Tel: 01895 250230
Case Officer: Michael Gavin
Email: MGavin@hillingsdon.gov.uk
Date: 12th July 2021
Our Ref: 40711/PRC/2021/102

RE: Amendment to roof and building levels and reduction in density from 2 x 3 Bedroom and 4 x 2 Bedroom flats as previously approved under 40711/APP/2018/4033 to 4 x 3 Bedroom flats & 1 x 2 Bedroom flats

SITE: 27 Ducks Hill Road Northwood

PROPOSED FLANK/SOUTH ELEVATION

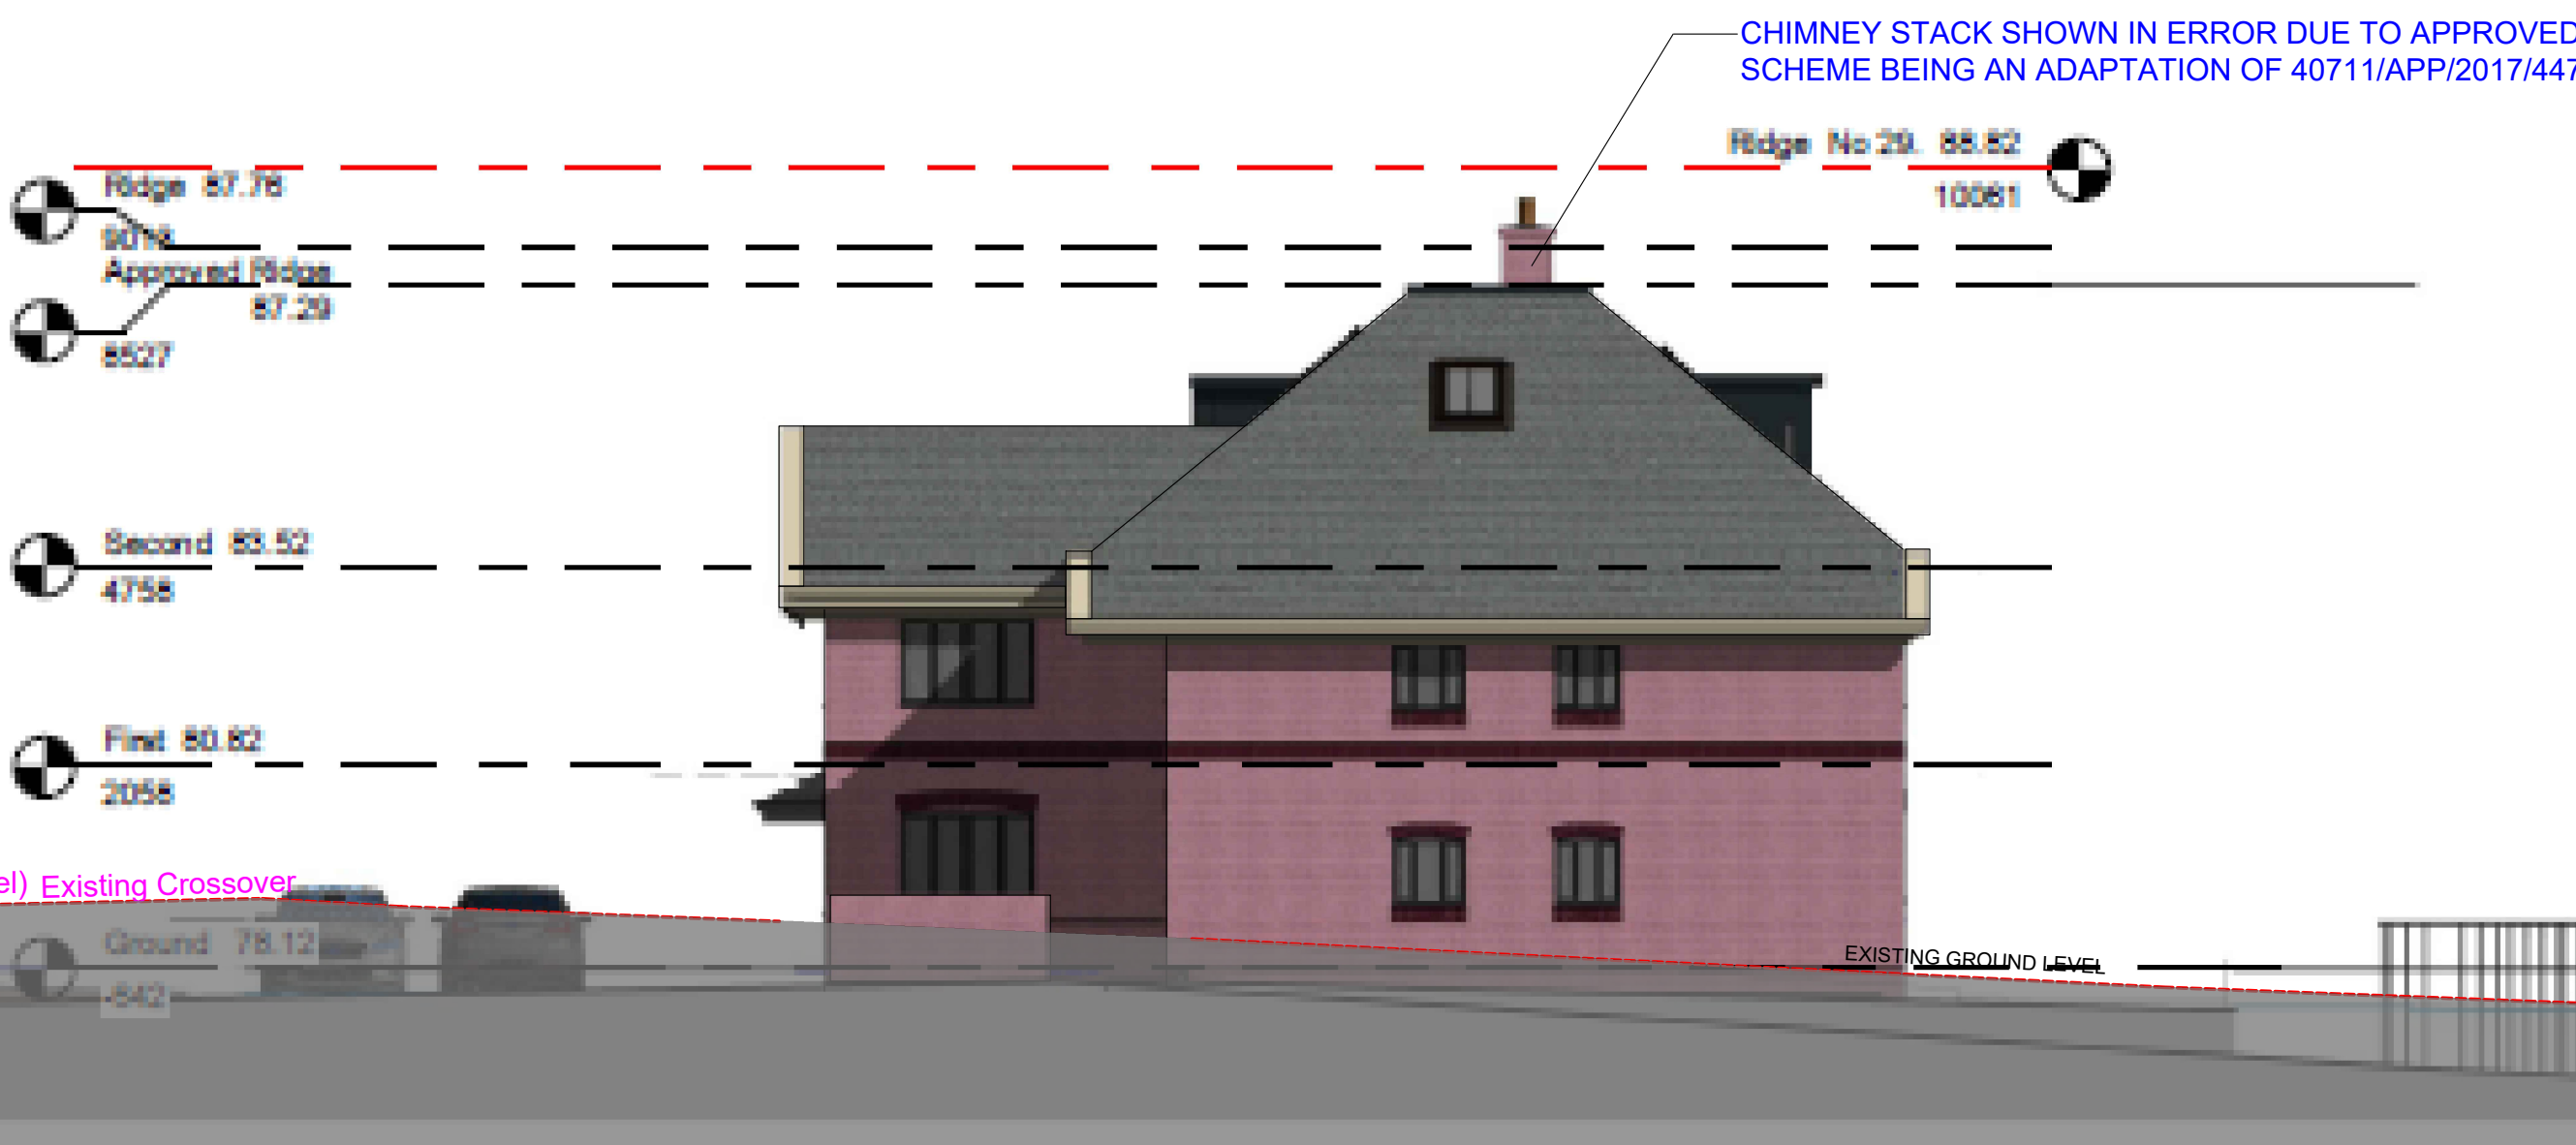
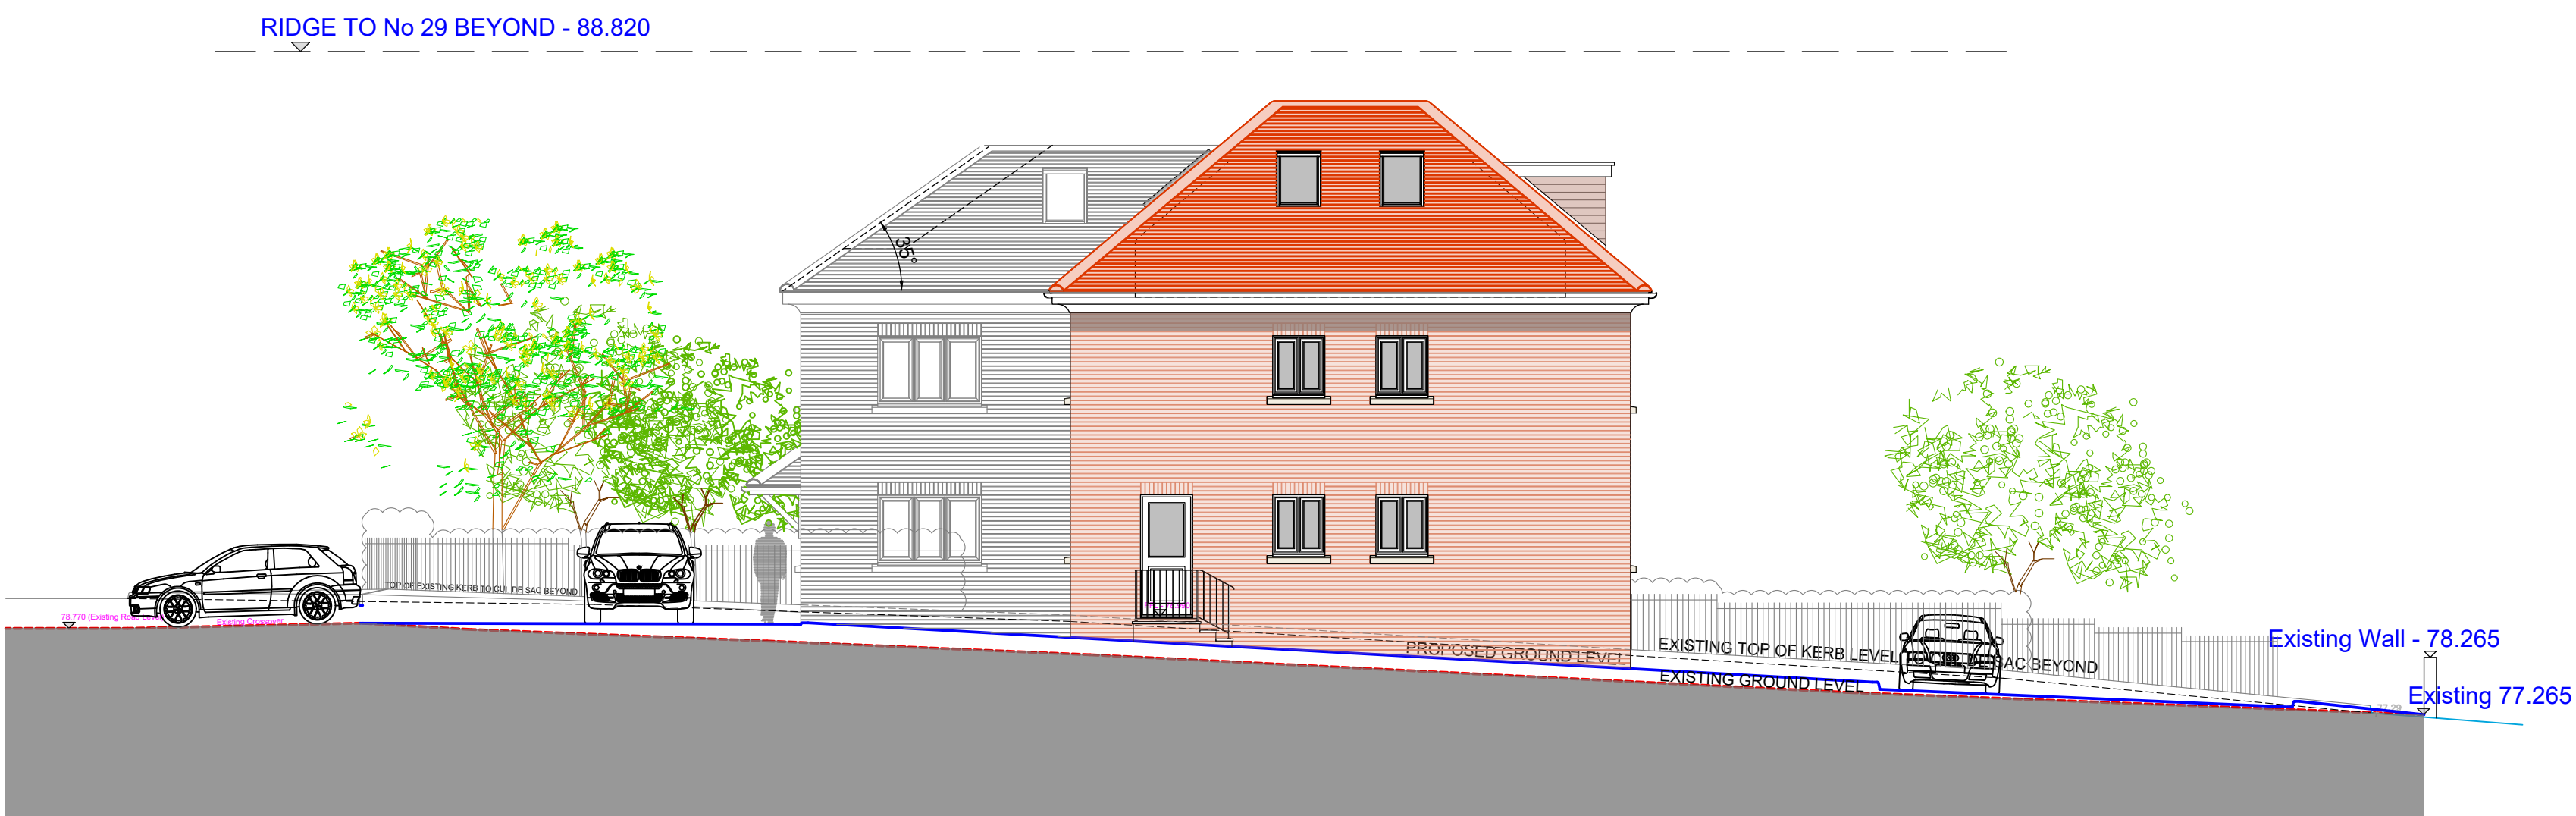
- omitting central front dormer
- adding design detail to twin-gabled projection front elevation
- increasing the height of the roof relative to building below, while still keeping the roof height 0.93m below that of 29 Ducks Hill Road, to address the issues raised of a somewhat squat appearance

I consider these changes improve the building's appearance compared to that of the building refused under application ref. 40711/APP/2021/519, by reducing the relative bulk and massing of the roof form above the projecting front element. I remain somewhat concerned, however, that compared to the scheme approved under application ref.

40711/APP/2018/4033 the scheme as amended remains a less attractive building, by virtue of the loss of the overhanging eaves and bulky elevations. As discussed there appears to be scope to reduce the top floor flat in size and still remain in excess of the required GIA for this unit. I appreciate the reasons given in terms of head heights and usability but you may wish to explore further any possibility of further reducing the extent of crown roof over the front projection.
